RE: M12 EIS (SSI-9364) – Mirvac Submission

This letter has been prepared on behalf of Mirvac Projects Pty Ltd (Mircac), in response to the M12 Environmental Impact Statement (SSI-9364) that is on public exhibition until 18th November 2019.

The Elizabeth Enterprise Precinct

Figure 1-2 Key features of the project

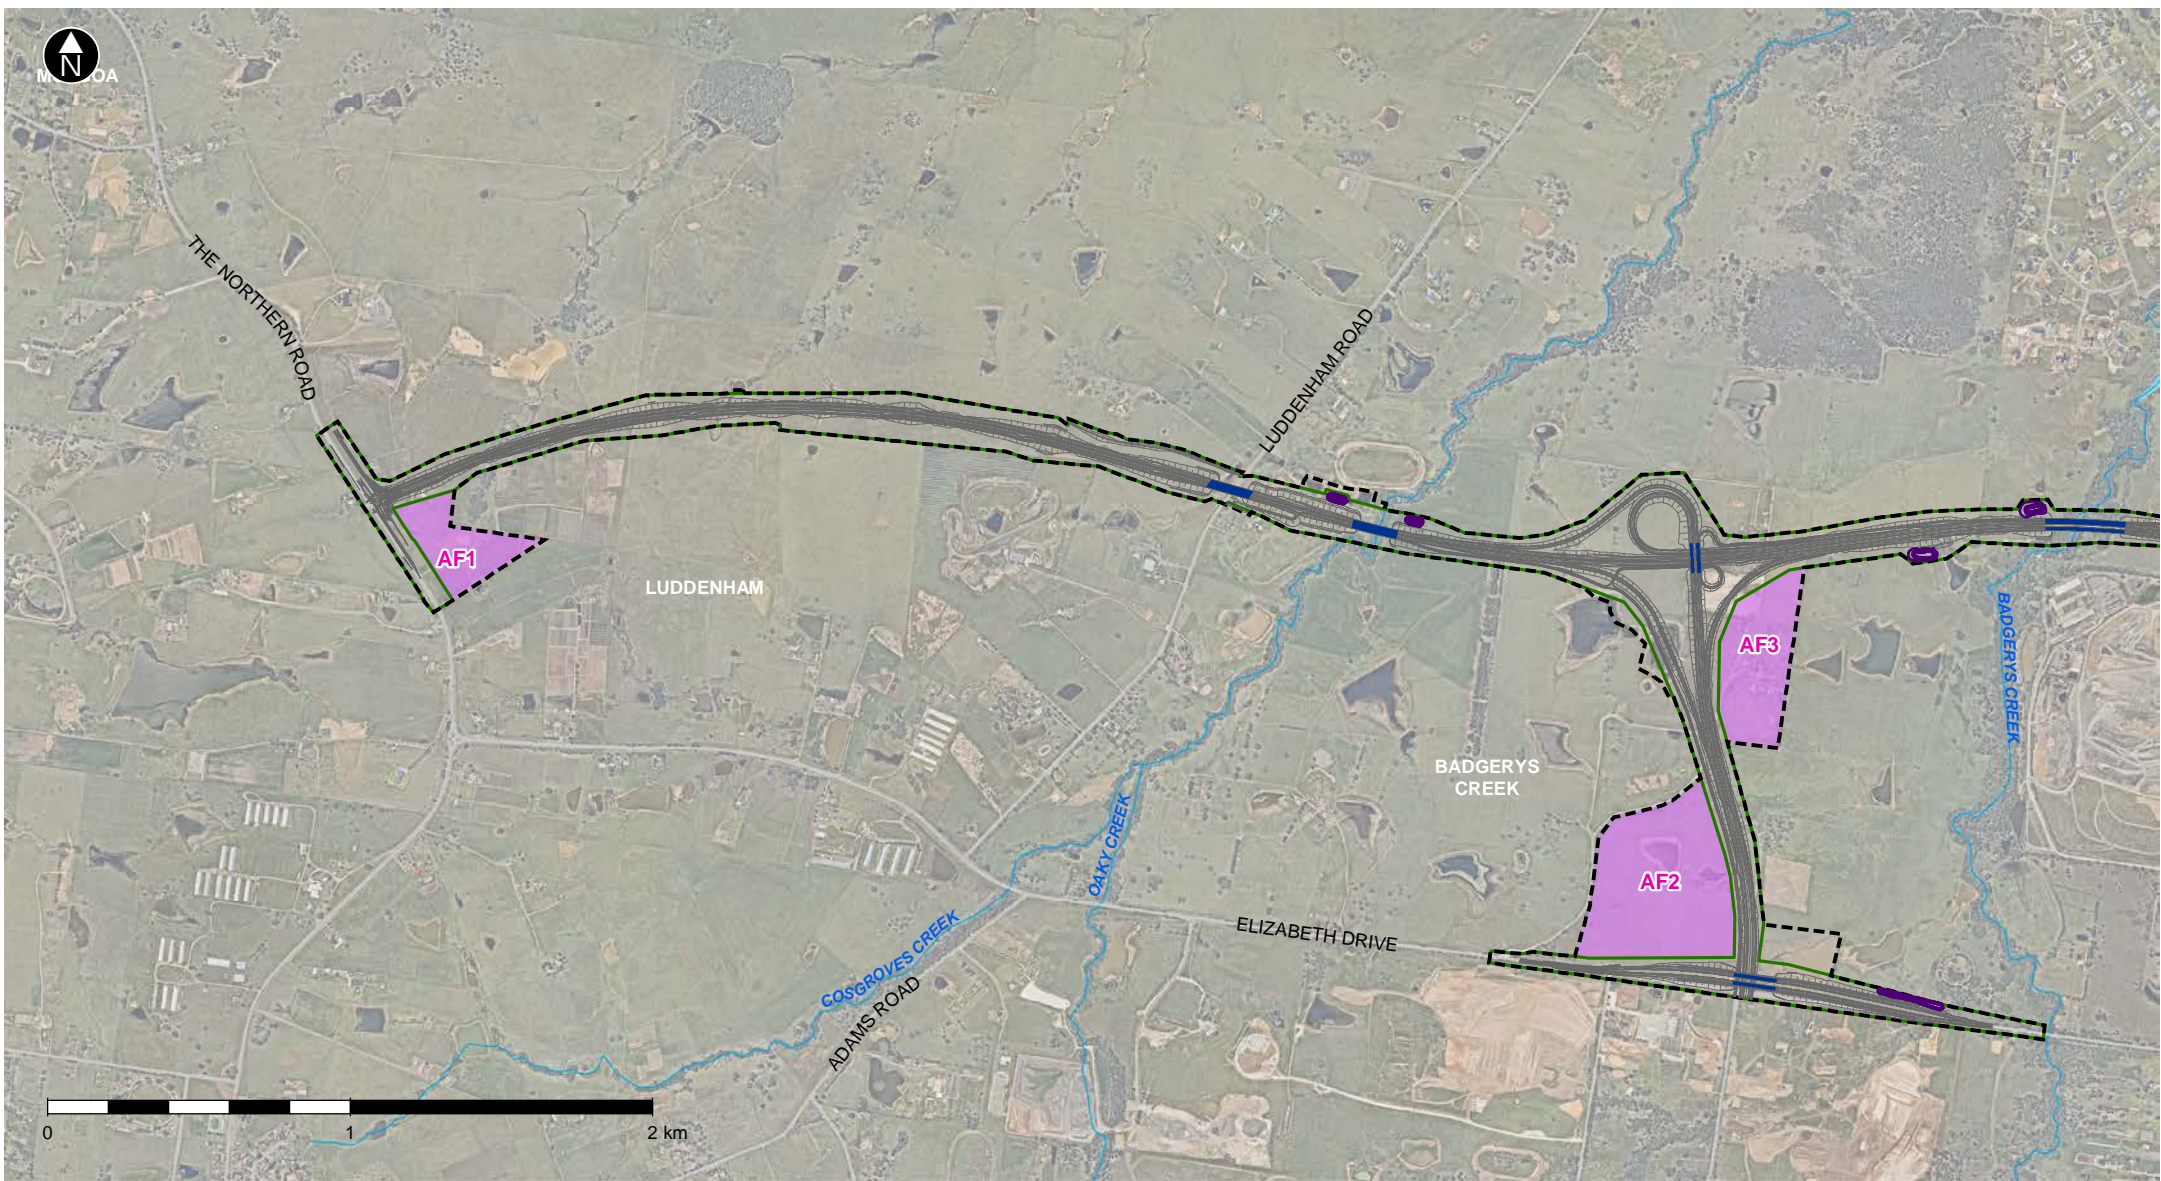
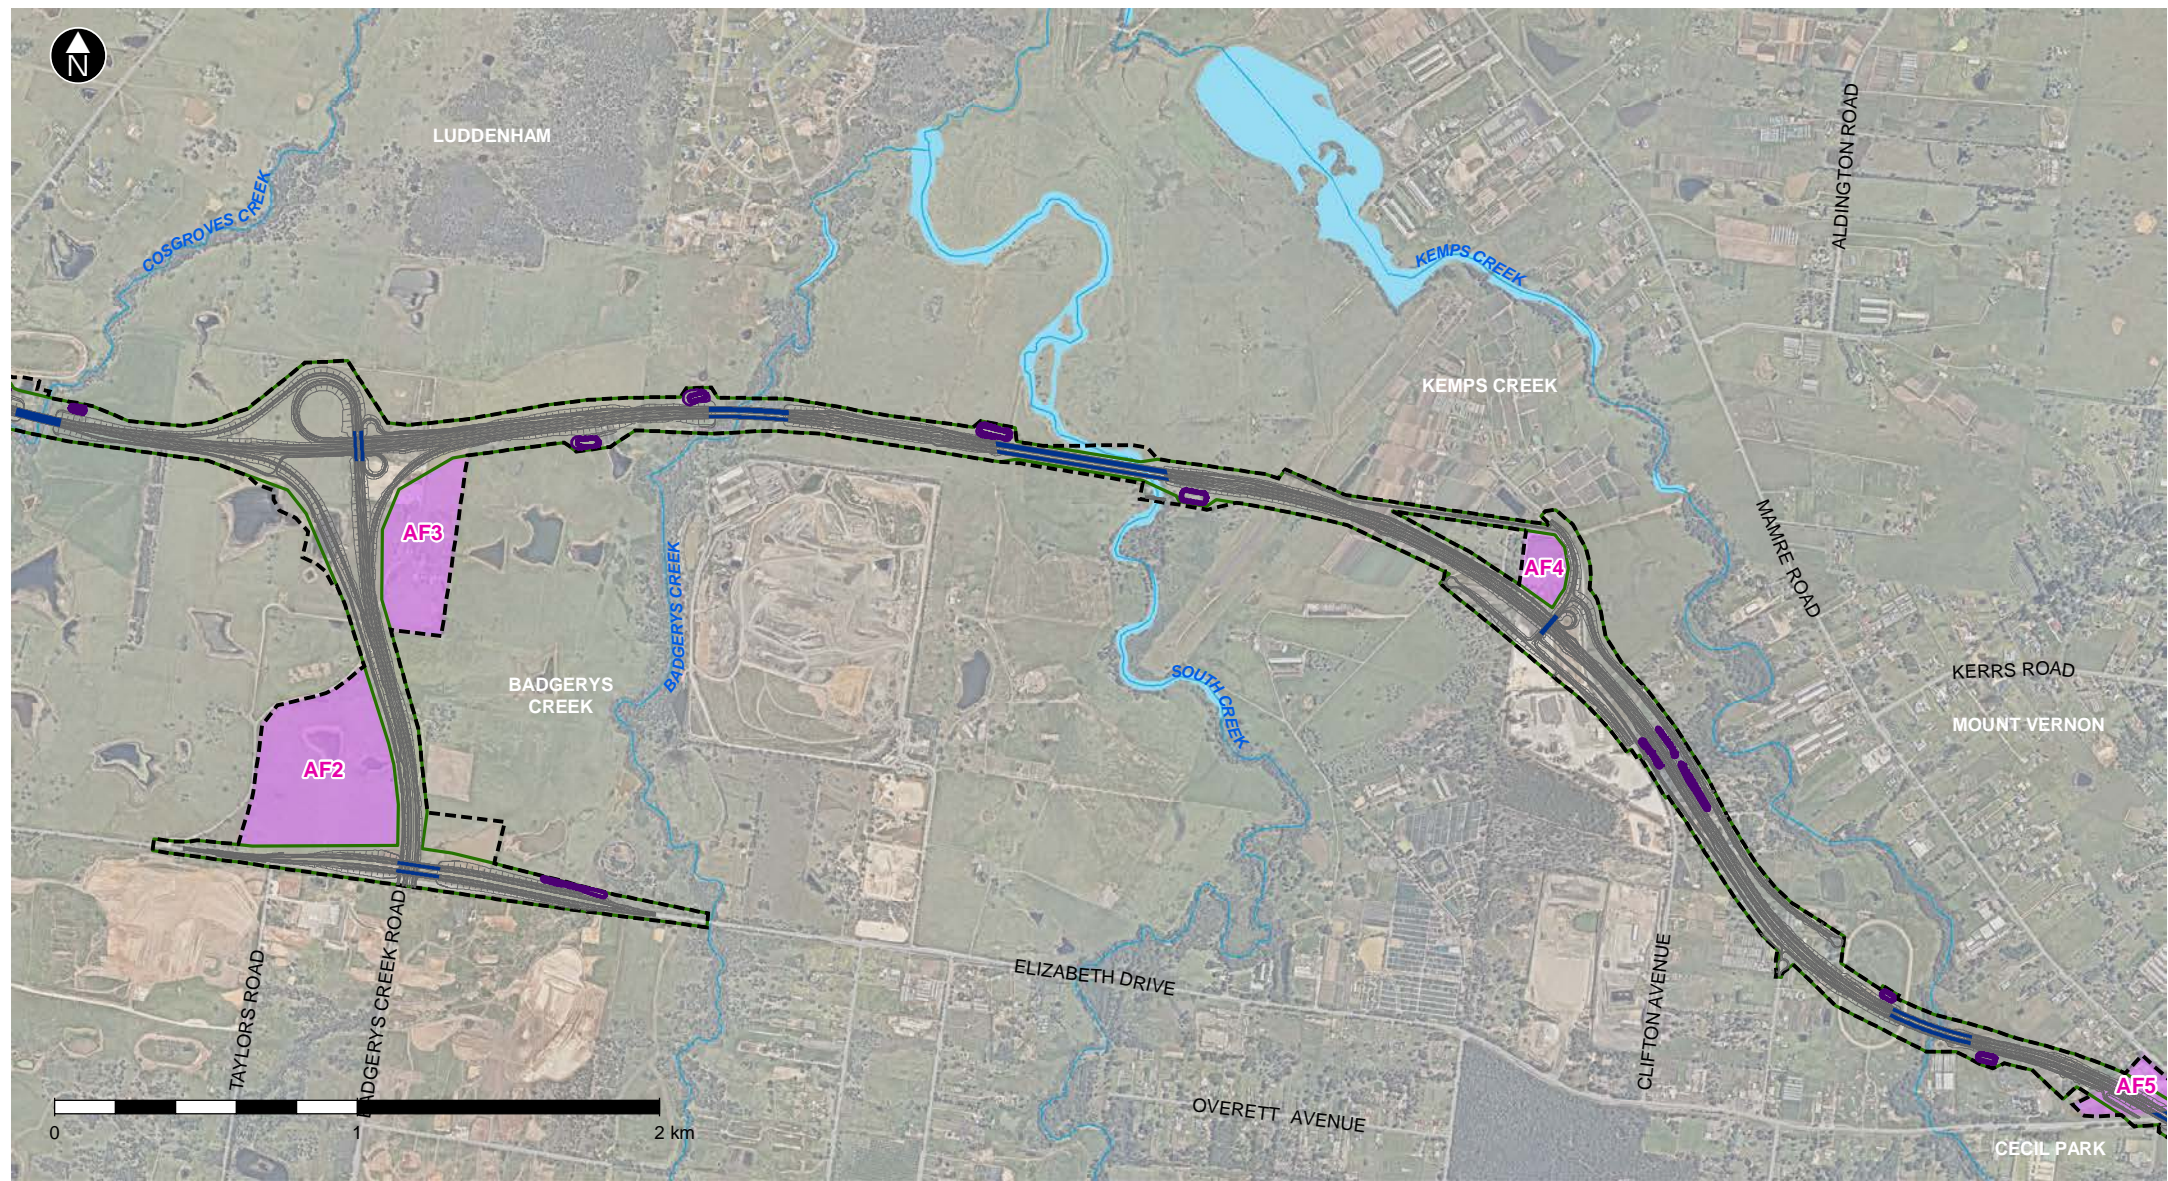
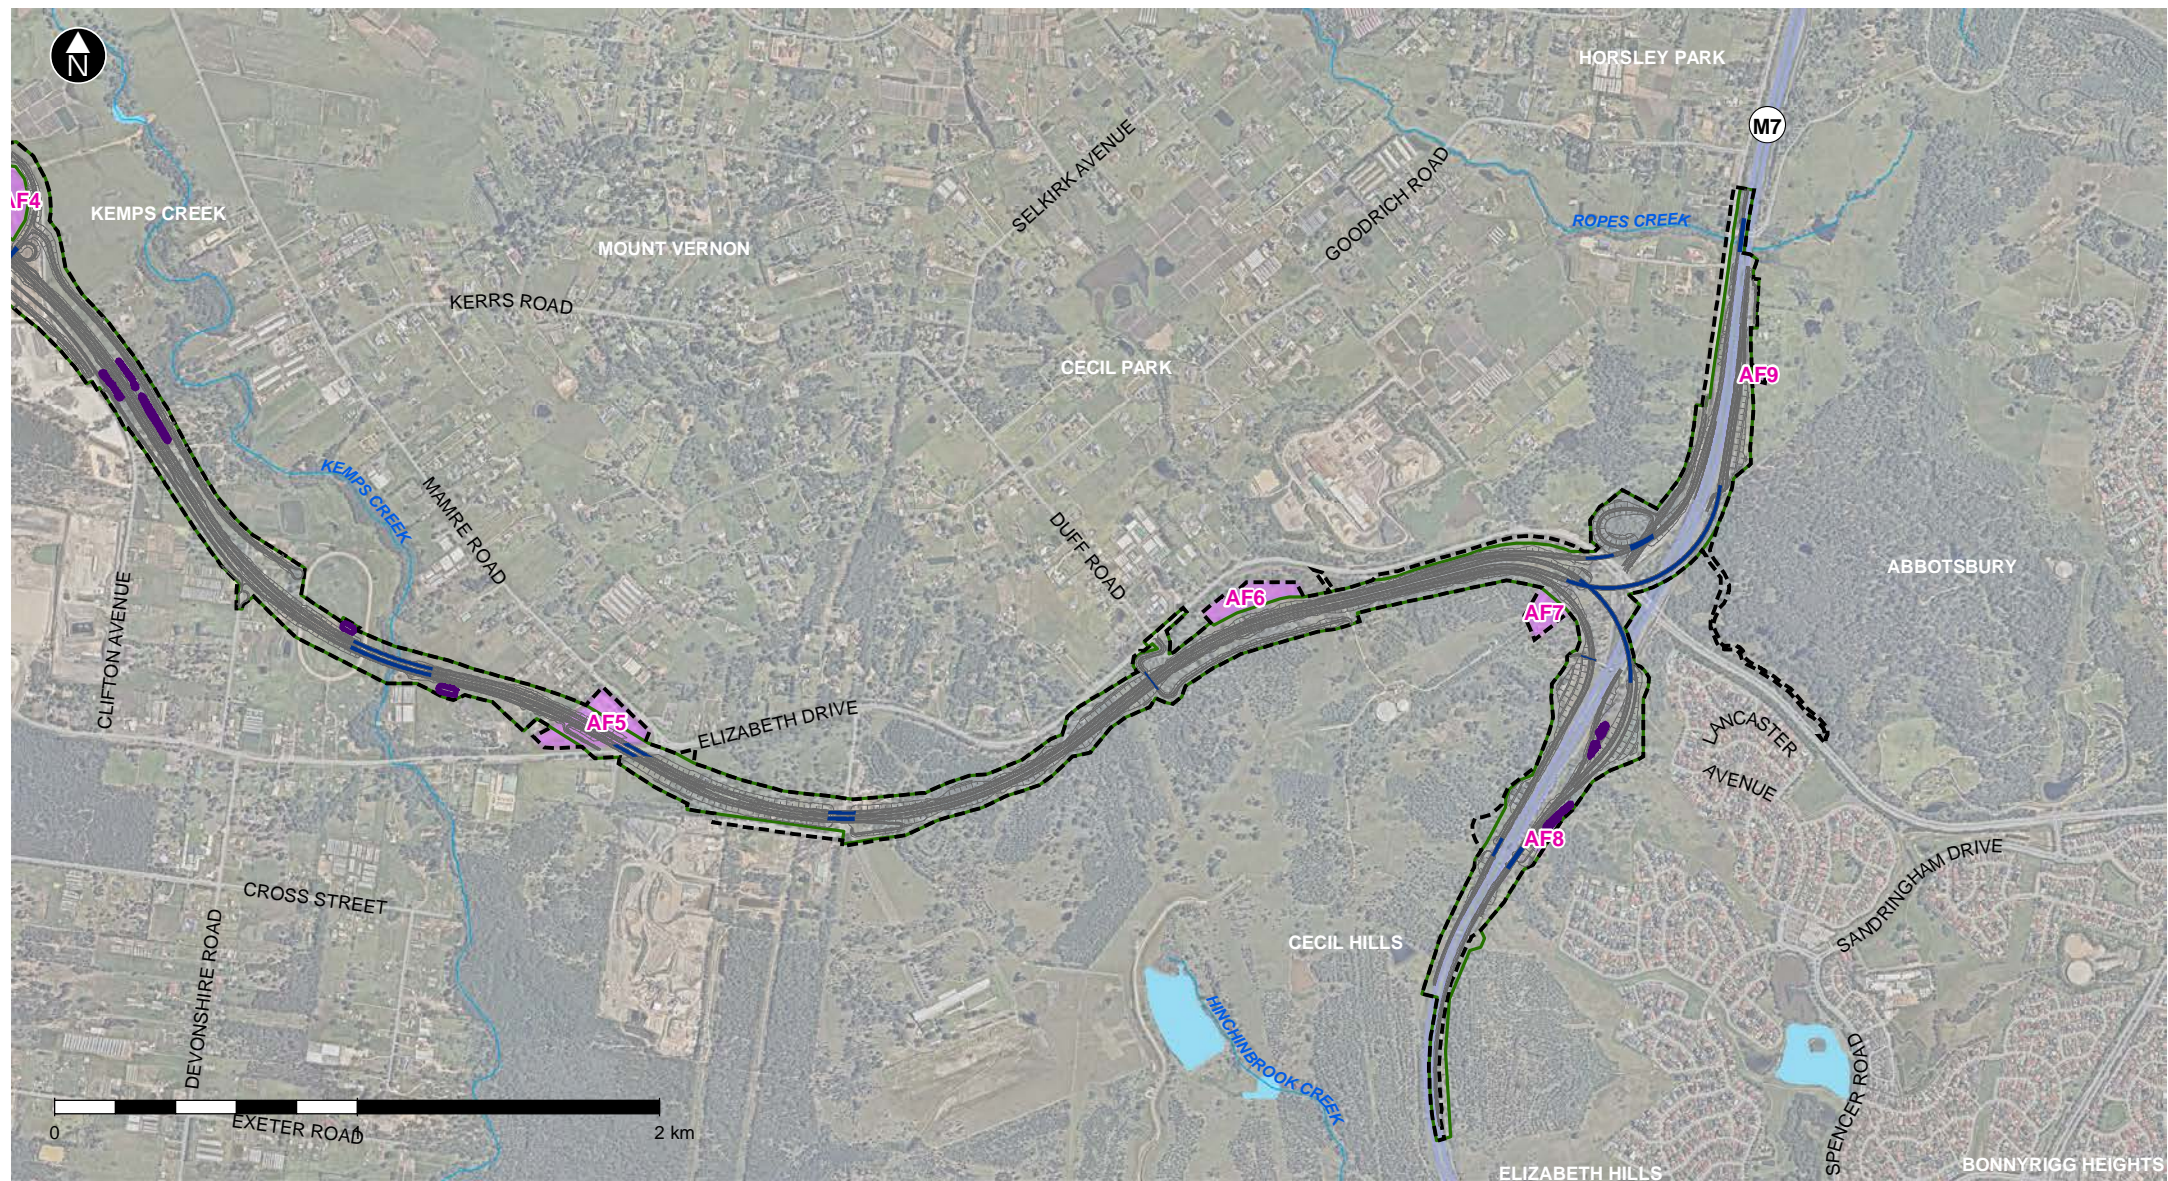
Adequate consideration is not given within the EIS for the M12 to have a connection to Elizabeth Drive to provide access to the M12 for the significant employment area that is identified within the Western Sydney Aerotropolis Land Use Infrastructure Implementation Plan (the LUIIP). It is appreciated that the focus is to provide access to the Western Sydney Airport from the major motorway network; however the Government also states above that the role of the project is to provide to the Aerotropolis and employment lands.

A connection between the M12 and Elizabeth Drive needs to be considered in the EIS. It is noted that should an Elizabeth Drive / M12 Motorway connection not be provided, all traffic using the M12 Motorway would have to travel through the Airport regardless of vehicle type or destination. It is assumed that this is not a desirable outcome in terms of efficient operation of the Airport and access to and from Elizabeth Drive would provide an important alternative entry / egress point to distribute traffic. As it stands with the current design; motorists who inadvertently took a wrong turn from the M7 to M12 motorway would be forced to travel some 8km to the airport and turn around inside the airport only to return some 8km back to the M7 Motorway. A direct connection to Elizabeth Drive at both the Western Sydney Airport and Devonshire / Mamre Road intersection will be essential to provide access to the Aerotropolis and surrounding employment lands.

Further, limiting the connectivity between the M12 and Elizabeth Drive would likely exacerbate the capacity constraints at the M7 / Elizabeth Drive, which currently operates poorly. As discussed above, providing a direct connection to Elizabeth Drive, which is expected to carry a significant volume of traffic in the future, would better distribute traffic across the road network, alleviating capacity constraints at the key intersection with the M7 to the east and The Northern Road to the west.

The EIS states that the bridge proposed for Clifton Avenue is currently designed for 9 metre single articulated vehicles. Clifton Avenue is in a location that has been identified for employment land and will provide important north-south connectivity to Elizabeth Drive for employment land bisected by the M12. Therefore, it is recommended that the design for the bridge across Clifton Avenue be revised so that it can accommodate the largest vehicles expected in the area, being B-Triple trucks.
